# CITY OF ALBUQUERQUE

May 31, 2017

**RE: McMahon Property  
Grading Plan  
Engineers Stamp Date: 5/25/17  
Hydrology File: A11D016**

Based on the information provided in your submittal received on 5/26/17, the Grading Plan is not approved for Grading Permit. The following comments must be addressed prior to approval:

MCMAHON PROPERTY			
TEMPORARY MASS GRADING PLAN			
 MARK GOODWIN & ASSOCIATES, P.A. CONSULTING ENGINEERS			
P.O. BOX 90606 ALBUQUERQUE, NEW MEXICO 87199 (505)828-2200, FAX (505)797-9539			
Designed: TB	Drawn: TB	Checked: DMG	Sheet 1 of 1
Scale: 1" = 30'	Date: 5/25/2017	Job: A17027

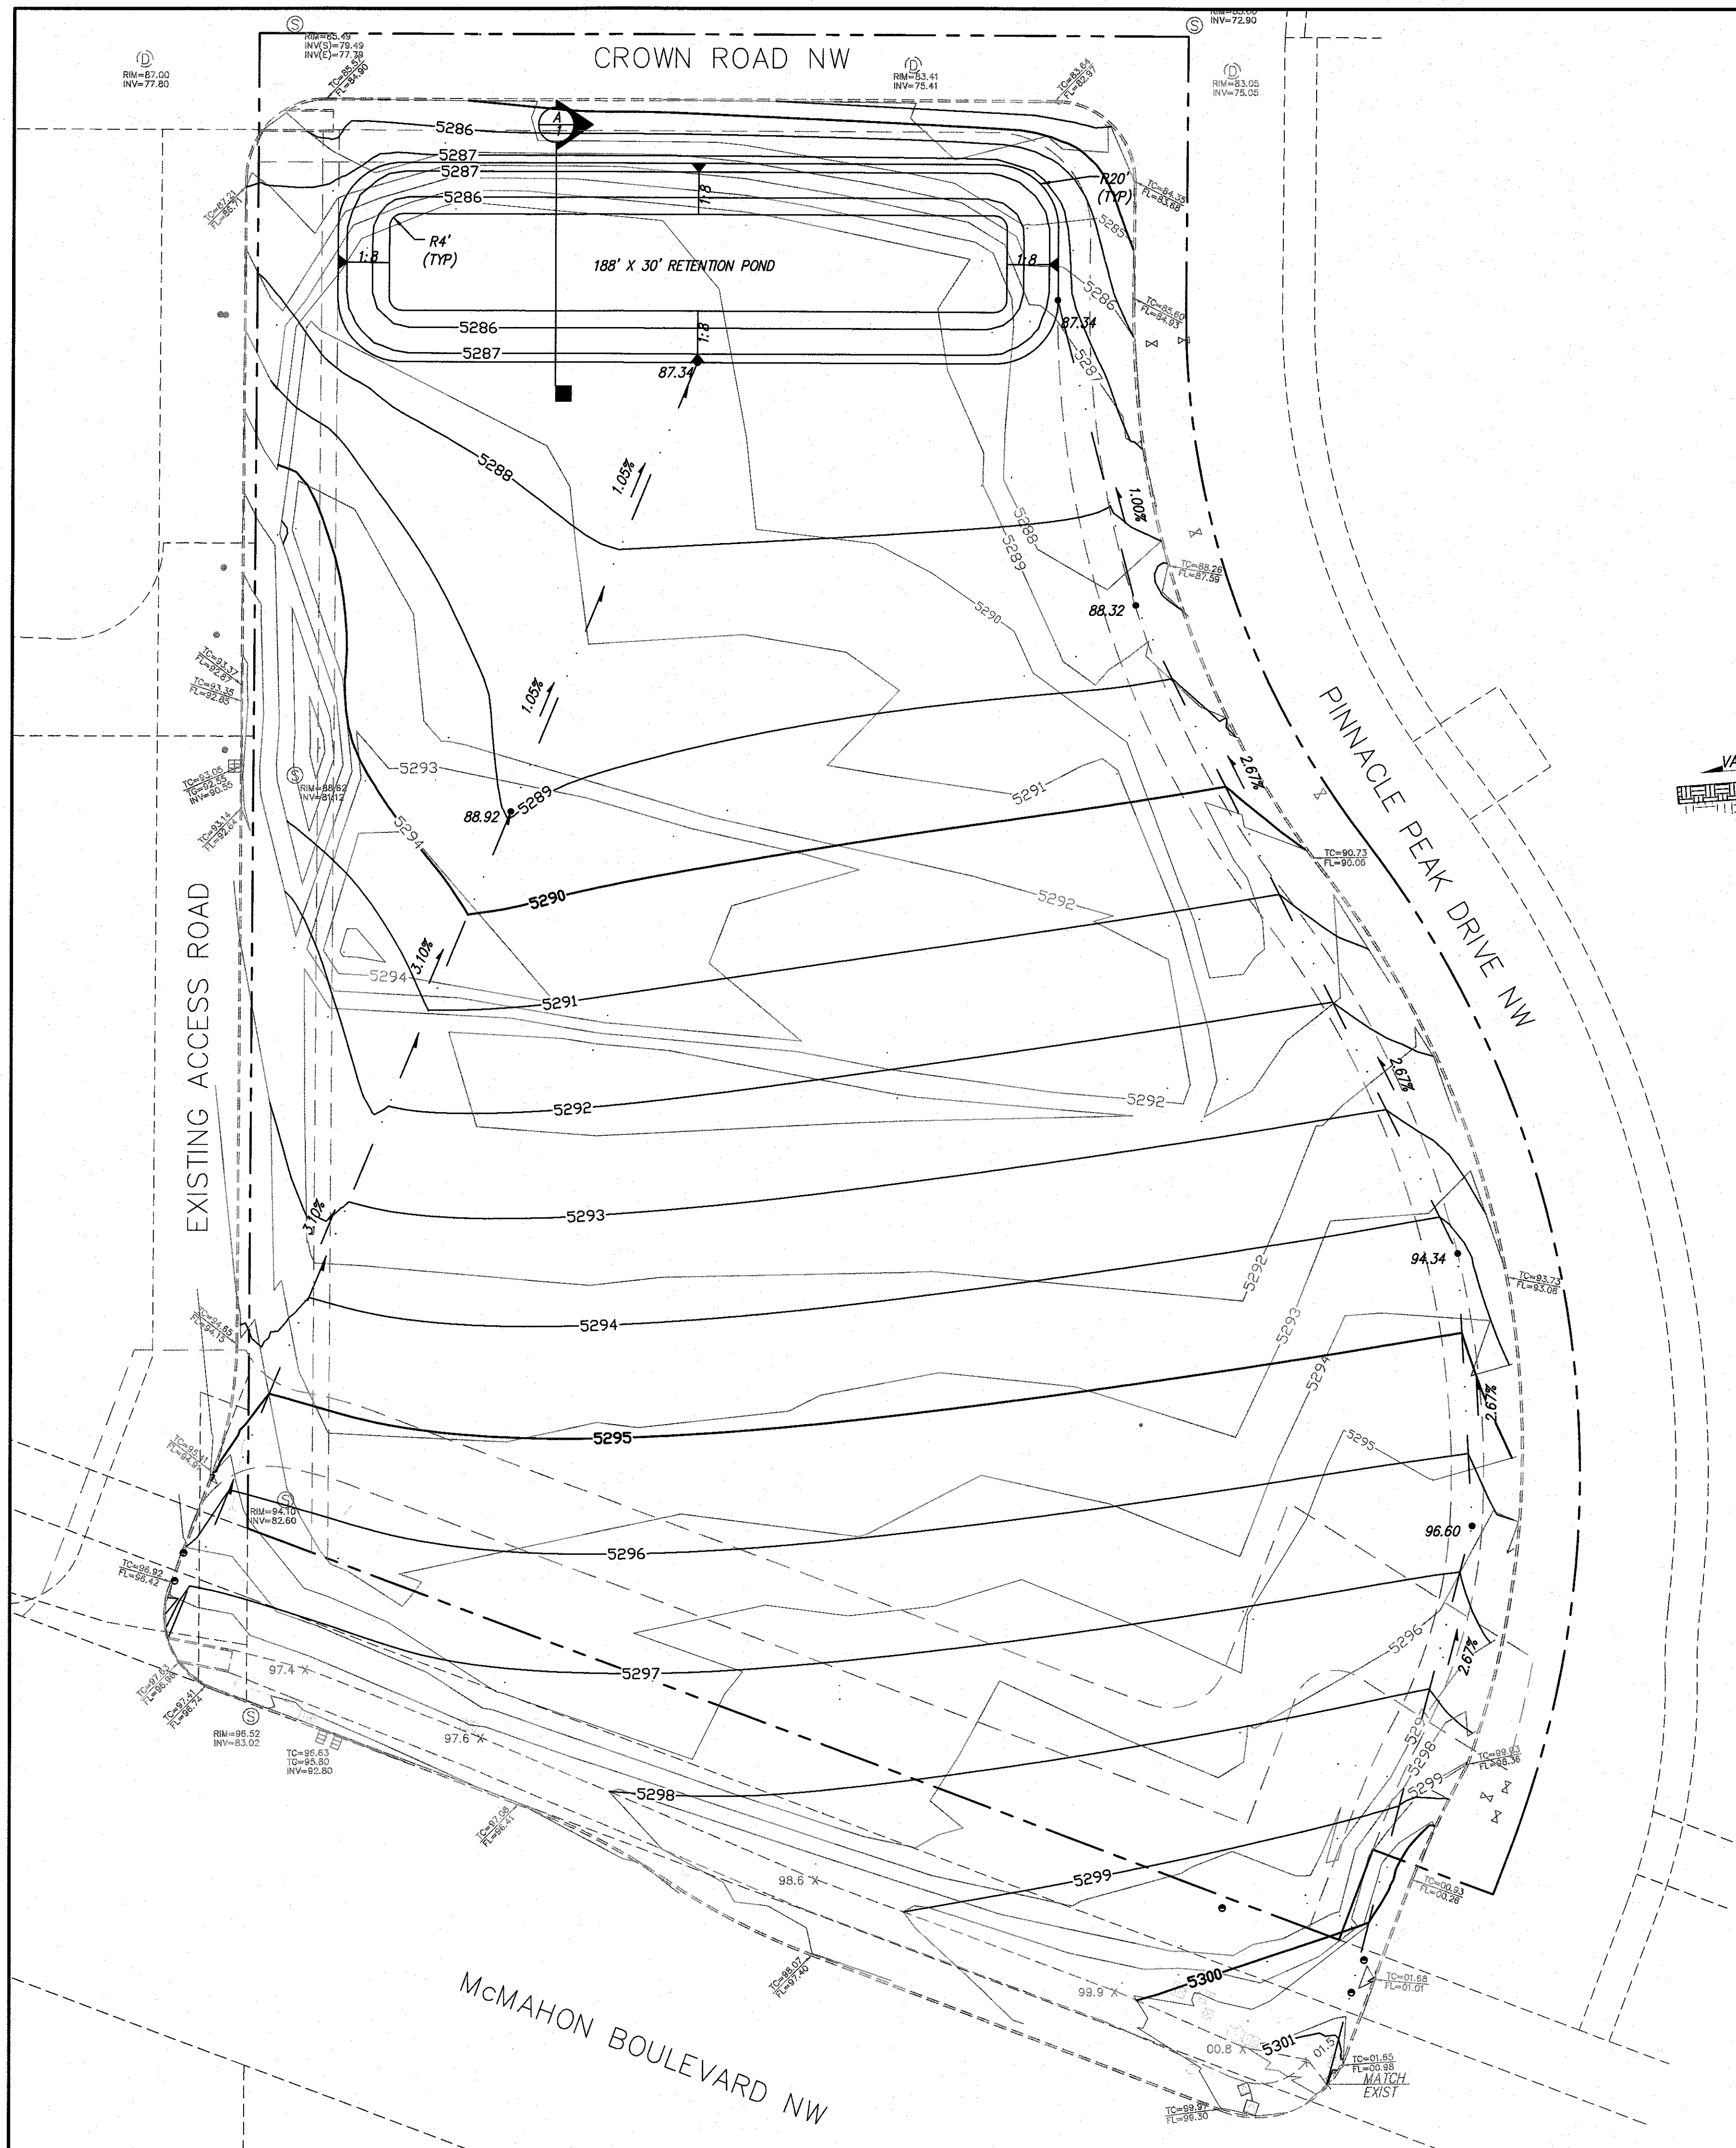
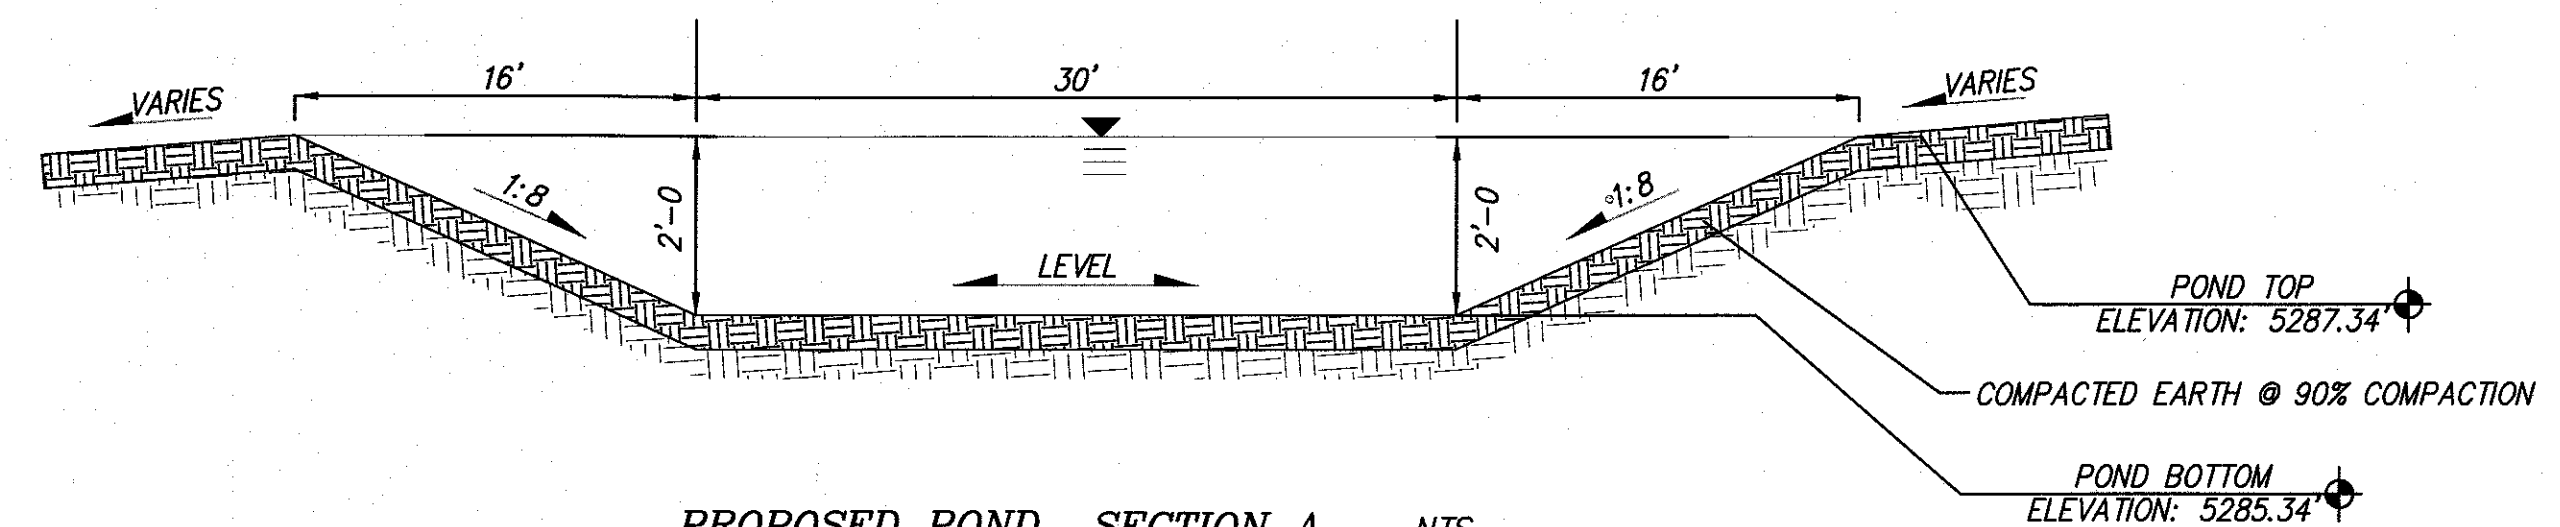
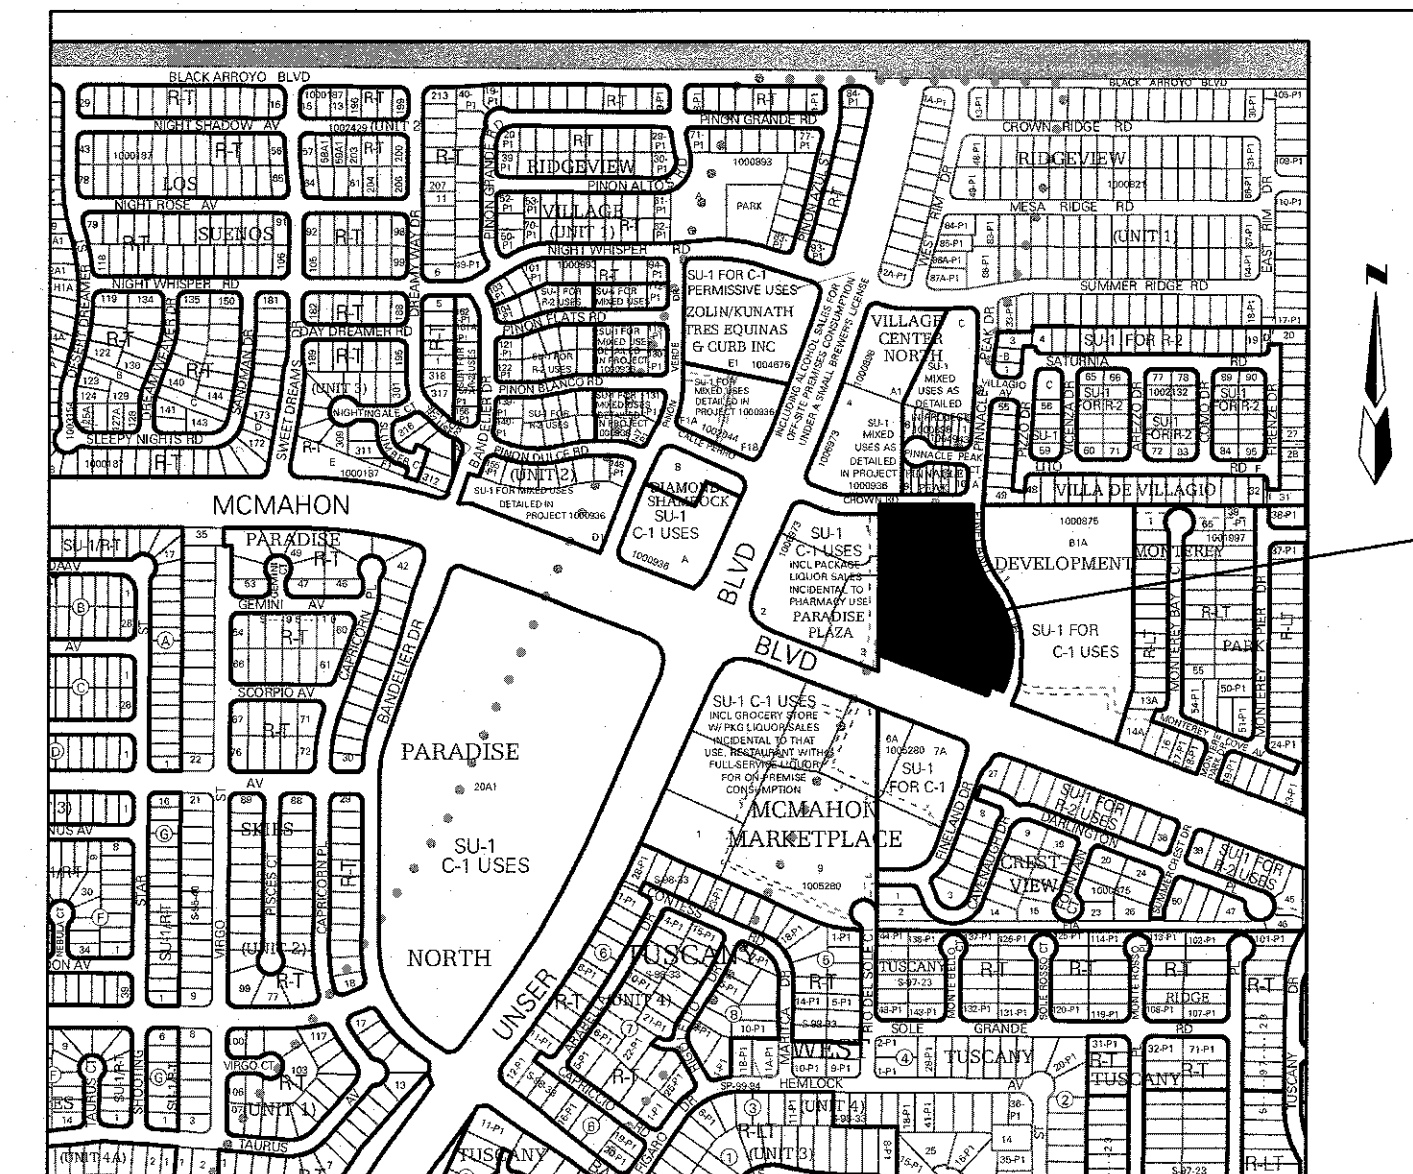
1. Provide project benchmark and elevation data.
2. Grading and compaction of the site as proposed will result in a land treatment Type C, not Type A as indicated.
3. The pond must be sized to retain the 10-day, 100-yr volume.
4. Supporting calculations need to be provided.
5. This work requires and ESC plan to be submitted to the storm water quality engineer (Curtis Cherne, PE [ccherne@cabq.gov](mailto:ccherne@cabq.gov)) prior to Grading Permit approval.
